Application No. 02DRB-00858 (P&F)  
Project Name: **PAINTED SKY SUBDIVISION UNIT 3**  
Agent: Precision Surveys Inc.

CITY OF ALBUQUERQUE  
PLANNING DEPARTMENT  
DEVELOPMENT REVIEW BOARD

**8. Project #1001998  
Application # 02DRB-00858  
Painted Sky Subdivision, Unit 3**

Plat of
 Tract "A"
**Painted Sky
 Subdivision Unit 3**

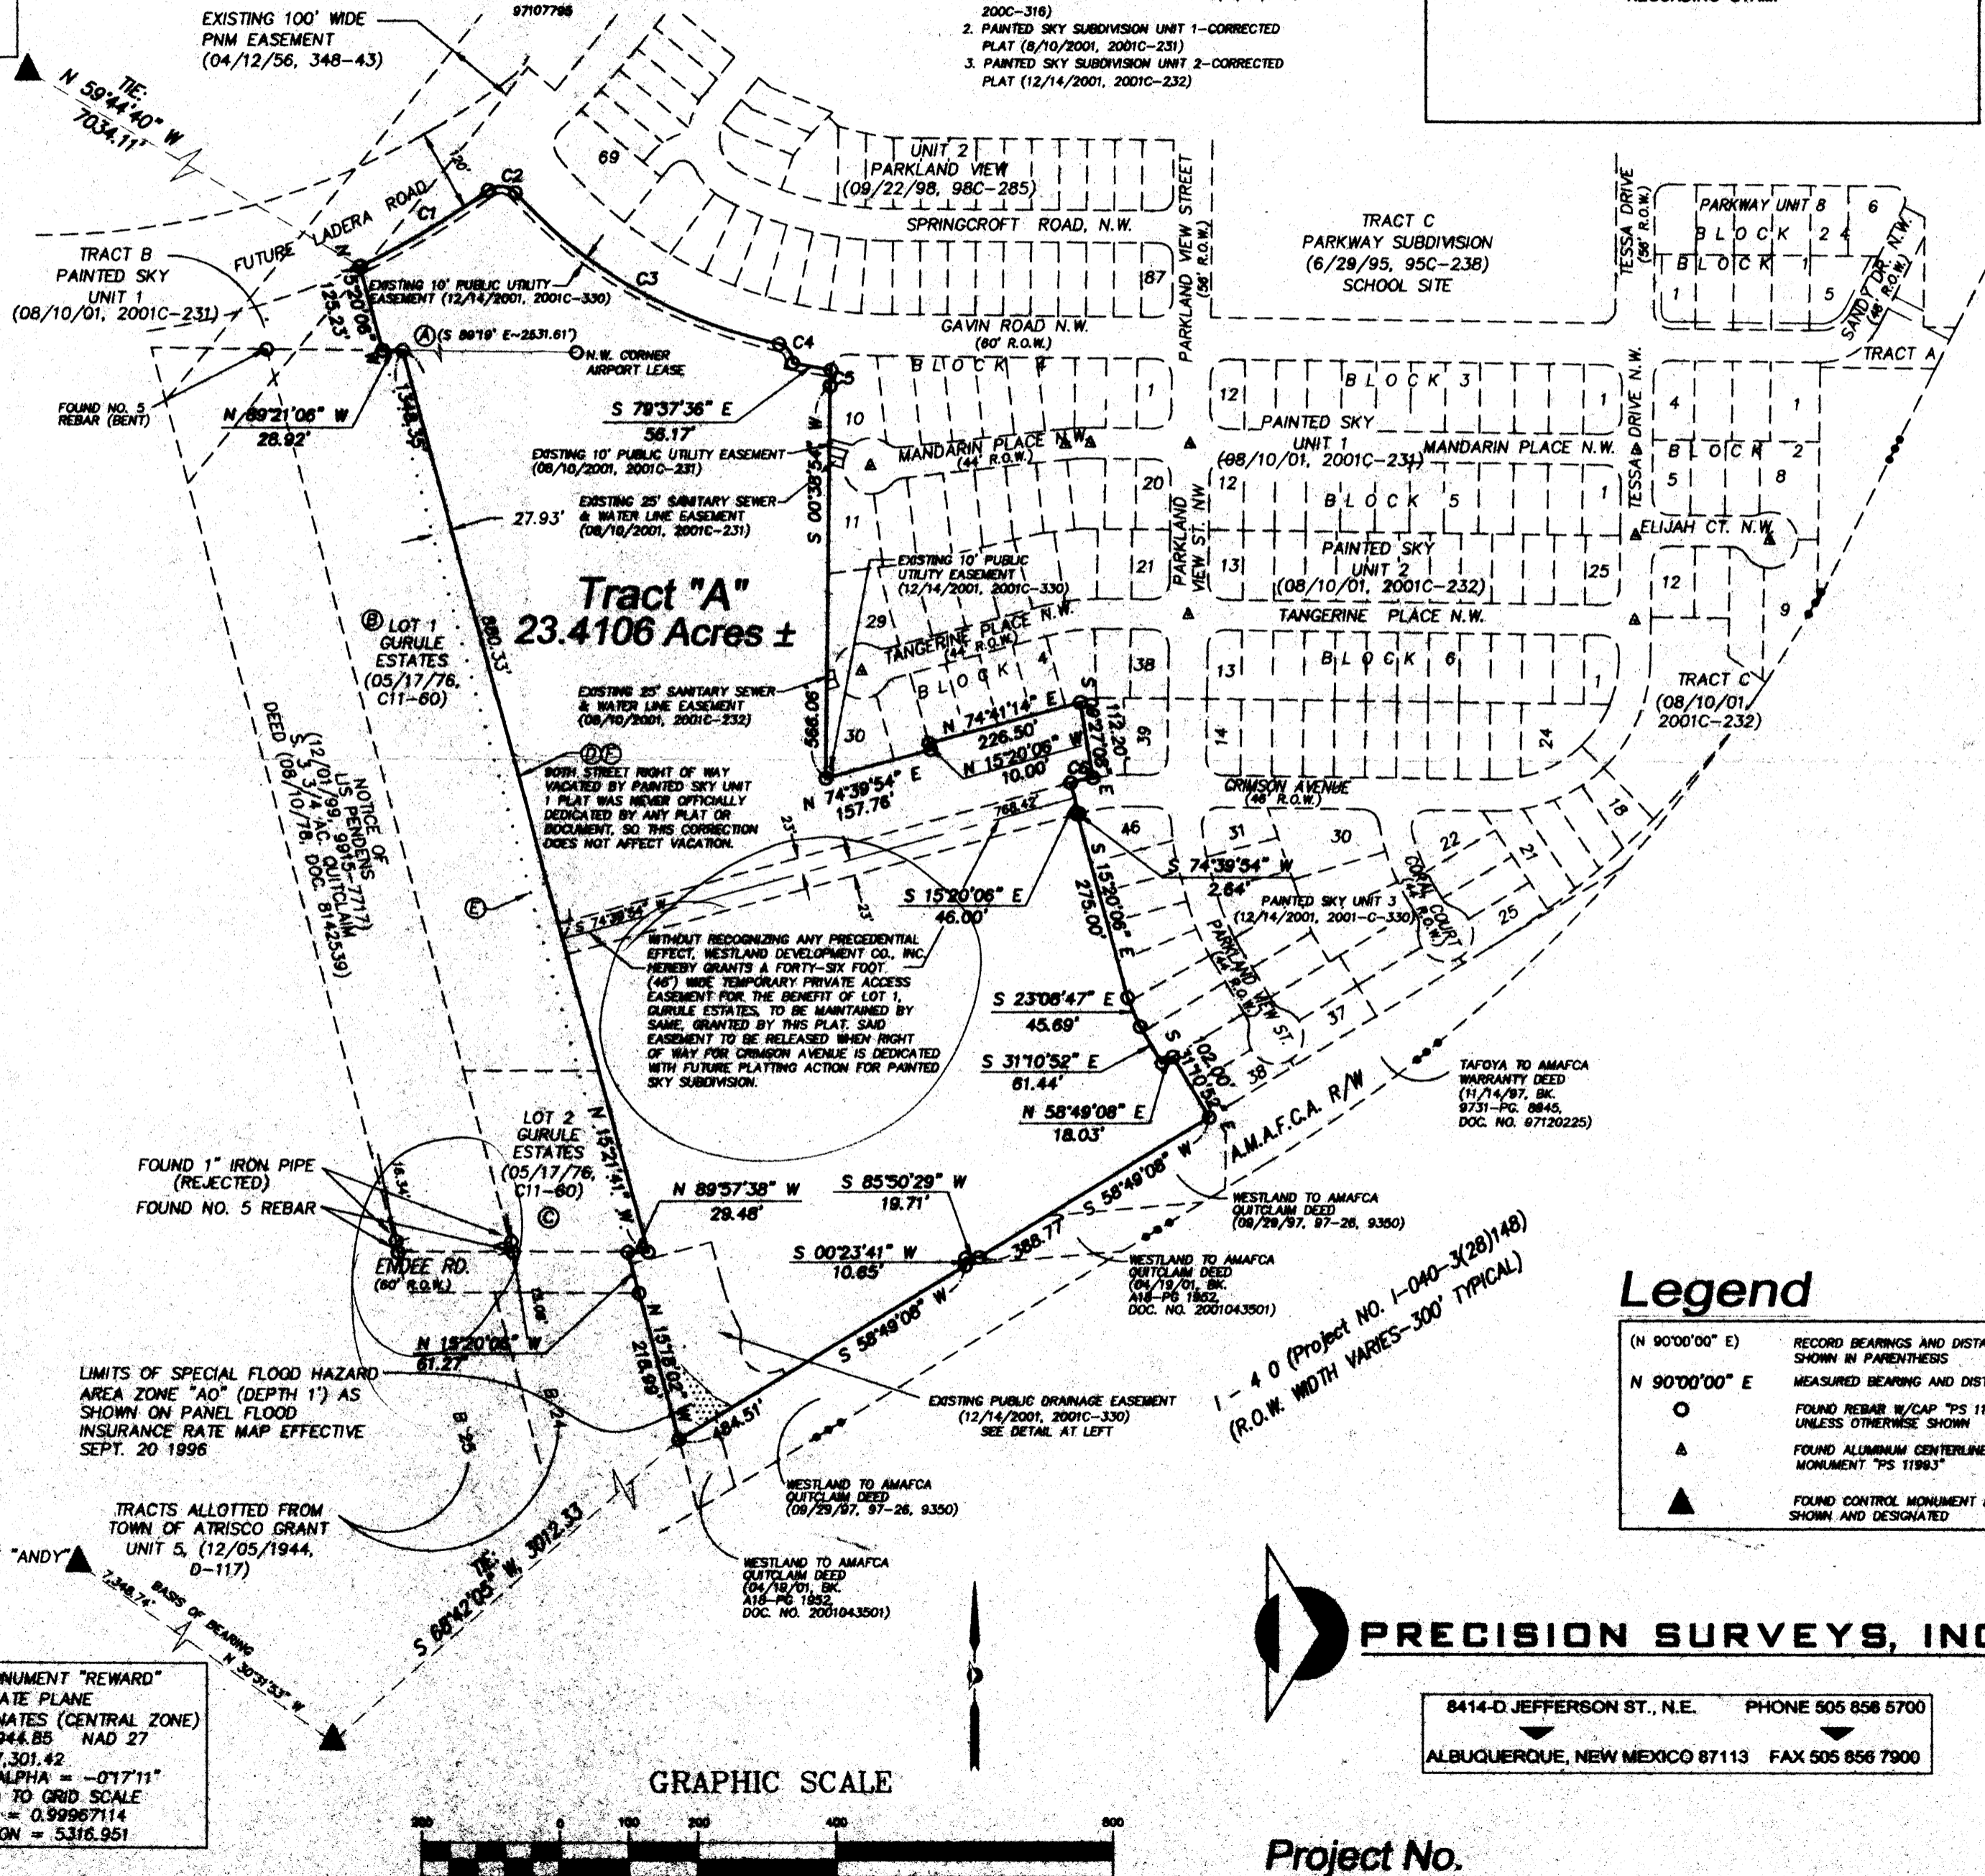
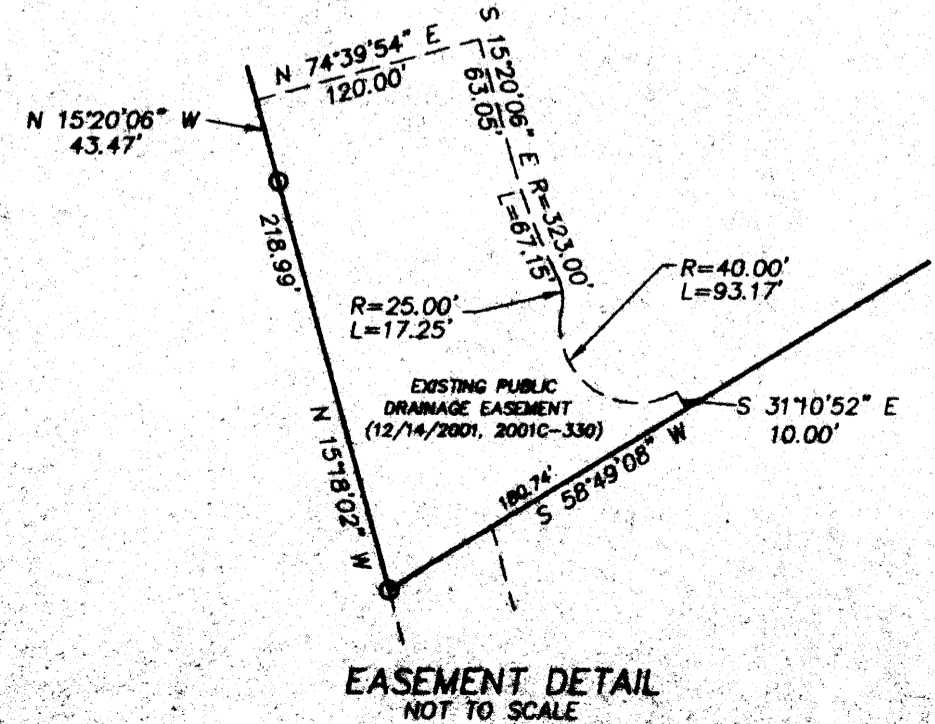
1. Include the Project # and Application # on the plat.
2. Regarding Note F, please make the following corrections:
  - Change the word "quit" to "quiet" title suit... (1<sup>st</sup> paragraph)

- Correct the year of the recording, i.e. "December 27, 200" (Subsection 1)
  - Add Predicanda S.'s last name. (Subsection 3)
3. Property Management's signature is required only on plats that vacate public right-of-way or dedicate parkland. Otherwise, the signature line may be marked "n/a".

No.	Comment
<input type="checkbox"/>	The easement note does not appear to be appropriate.
<input type="checkbox"/>	Access to the adjoining lots needs to be addressed.
